11 November 2016

**Re: Proposed New Habitat and Eco-Tourist Facility at Taronga Zoo (SSD 7419) -  
Response to Submissions**

GUEST LODGE ELEVATIONS

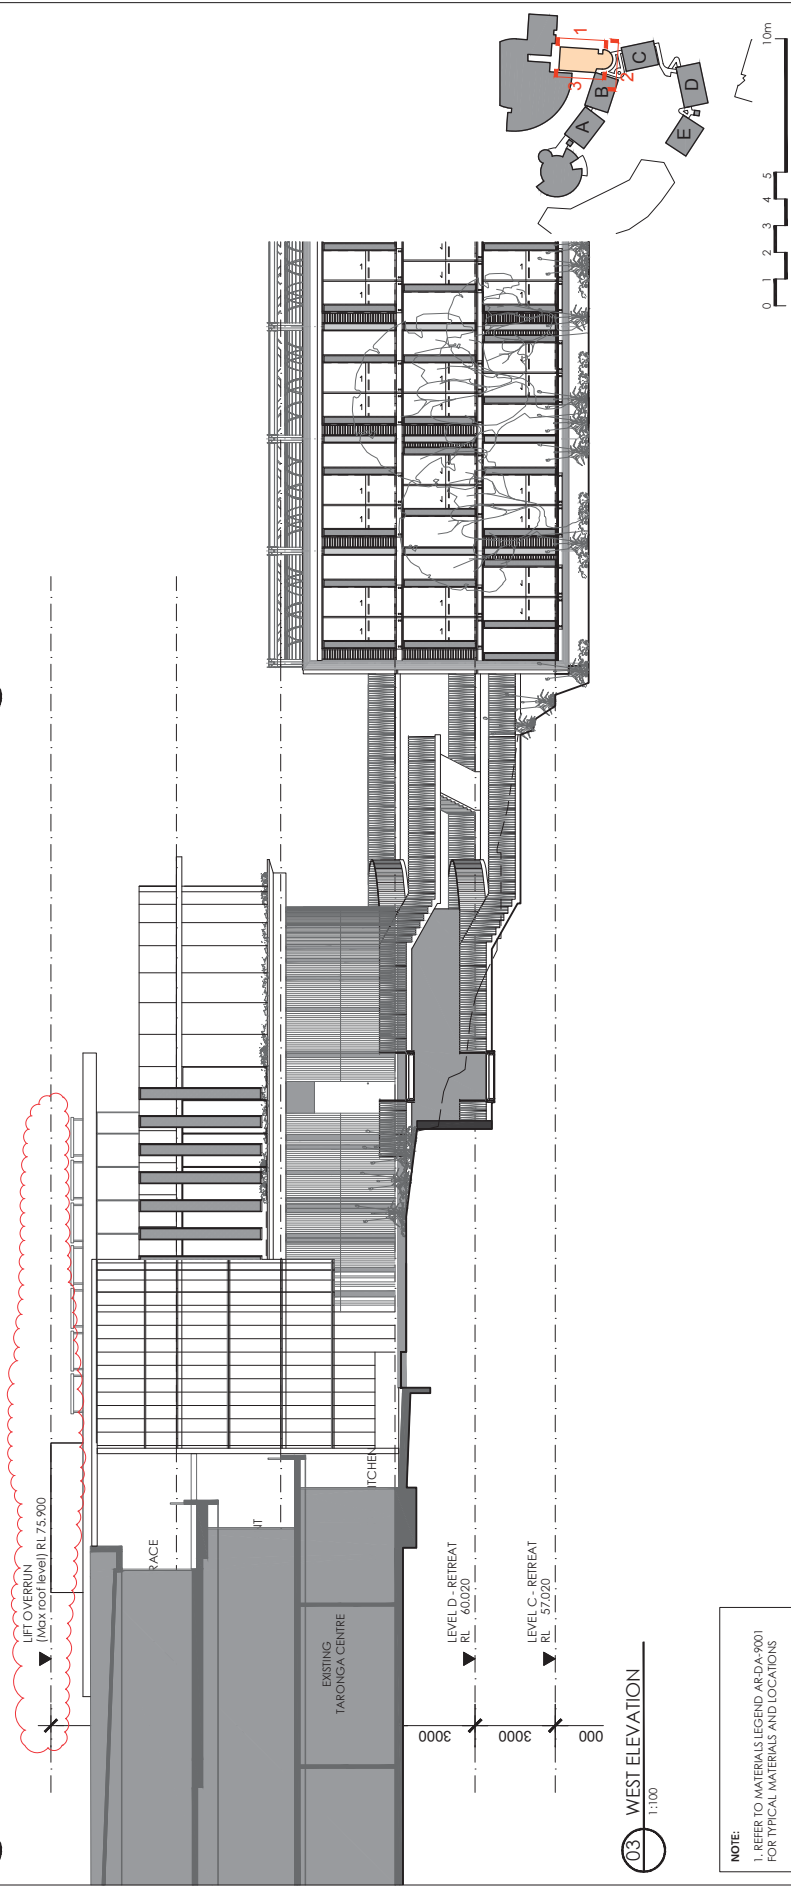
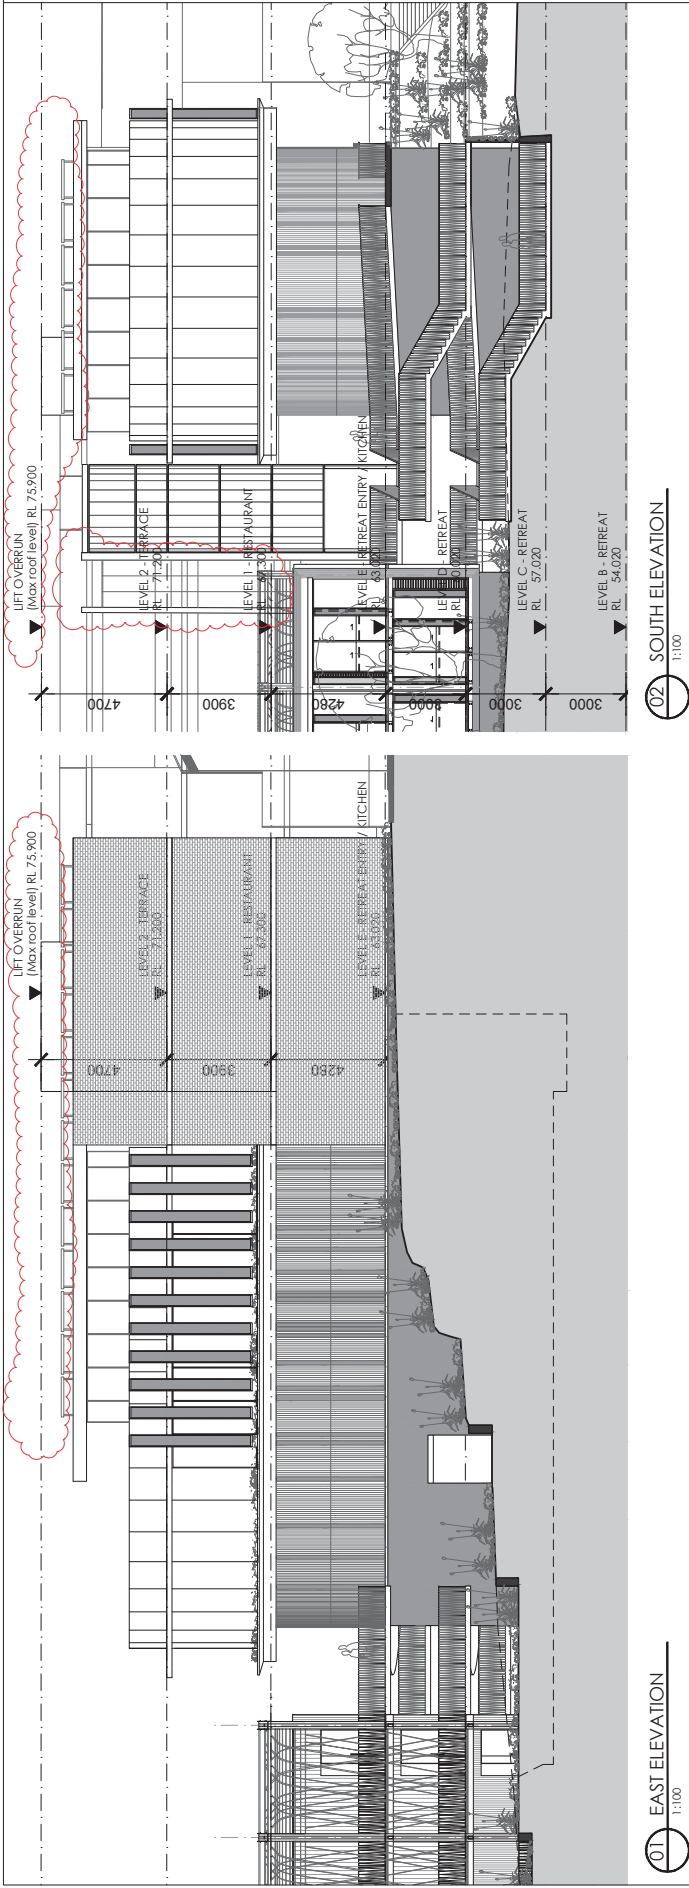
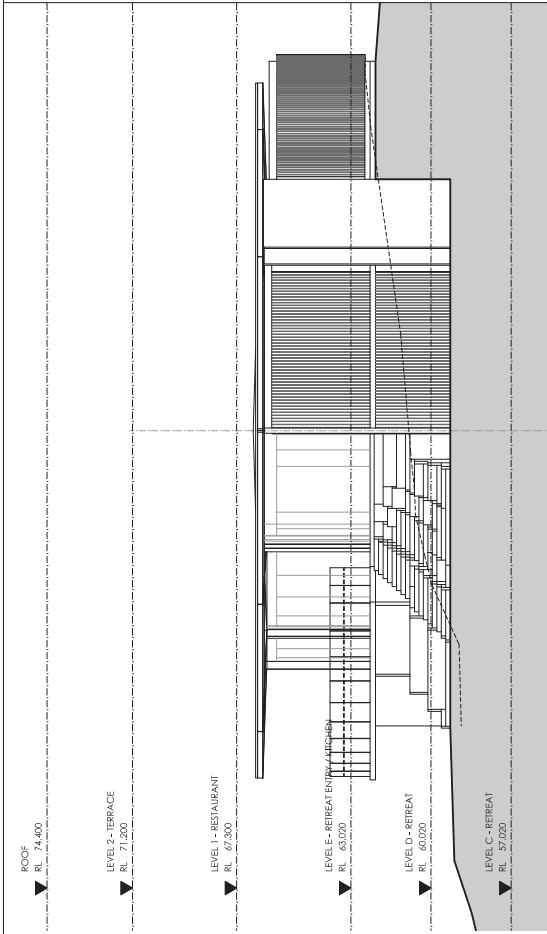
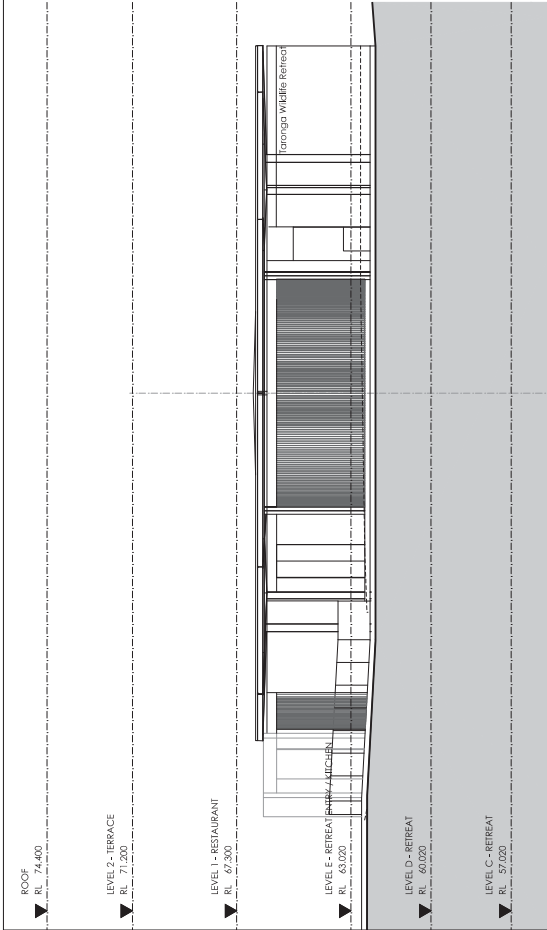
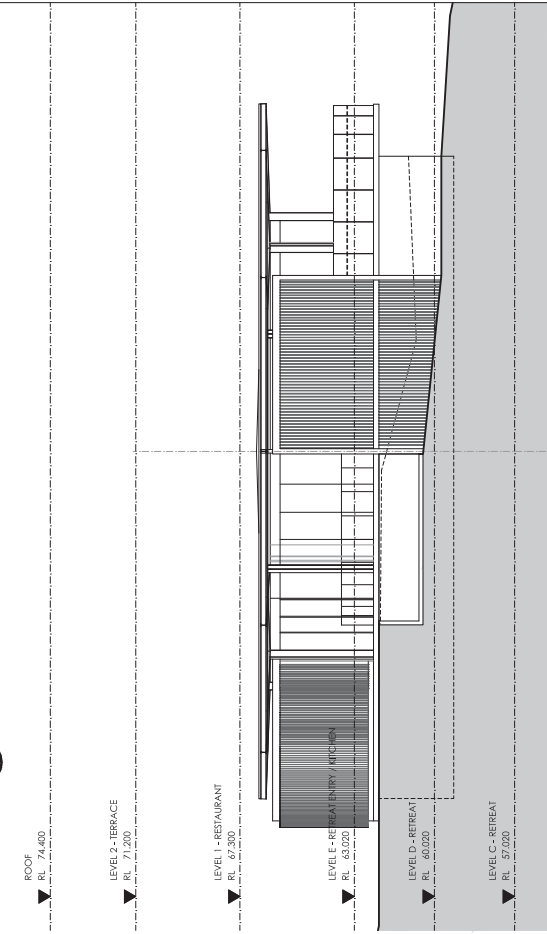
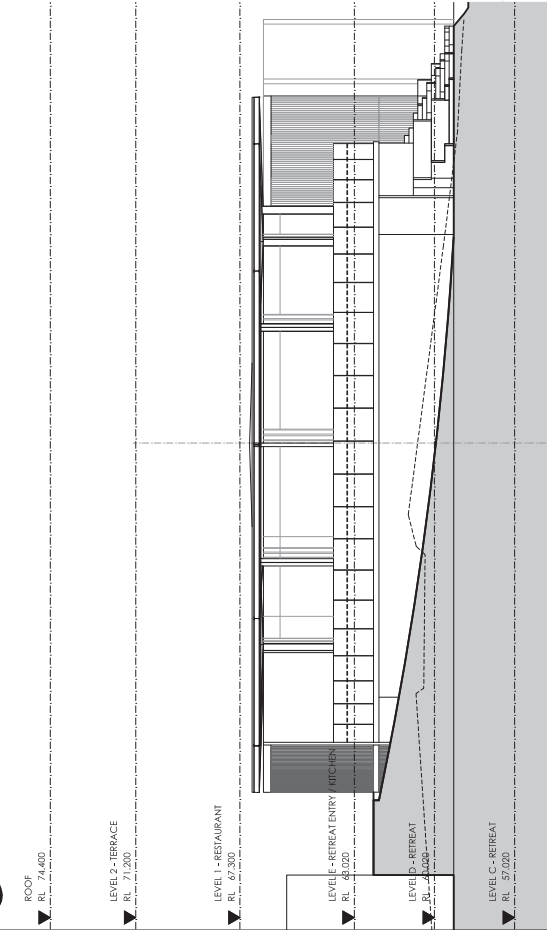
- Height of buildings: a significant extension to the existing function centre is proposed which would be at the highest point of the existing building. This structure would sit to the east and project south, above the proposed accommodation buildings. According to the information supplied by the applicant in the Operational Management Plan, dated 10 March 2016, the restaurant and terrace would be part of the facilities available to Retreat guests. This addition to the function centre would be visible from the harbour foreshores and a prominent structure. Further analysis of the impact of this building is required.

- The five accommodation buildings, referred to as 'pods' in the architectural plans vary in height from 2 storeys to four storeys. They are located on the sloping site to ensure views of the harbour are maintained from the existing function centre and views would be gained from the guest rooms. It is considered that a large 4 storey building would be incongruous with the objectives of the scenic protection area, the use of the site as a zoo and the context of other development on the vicinity. Despite the assessment in the EIS of visibility of the proposal from the harbour, it is considered likely that the development will be more visible than stated.
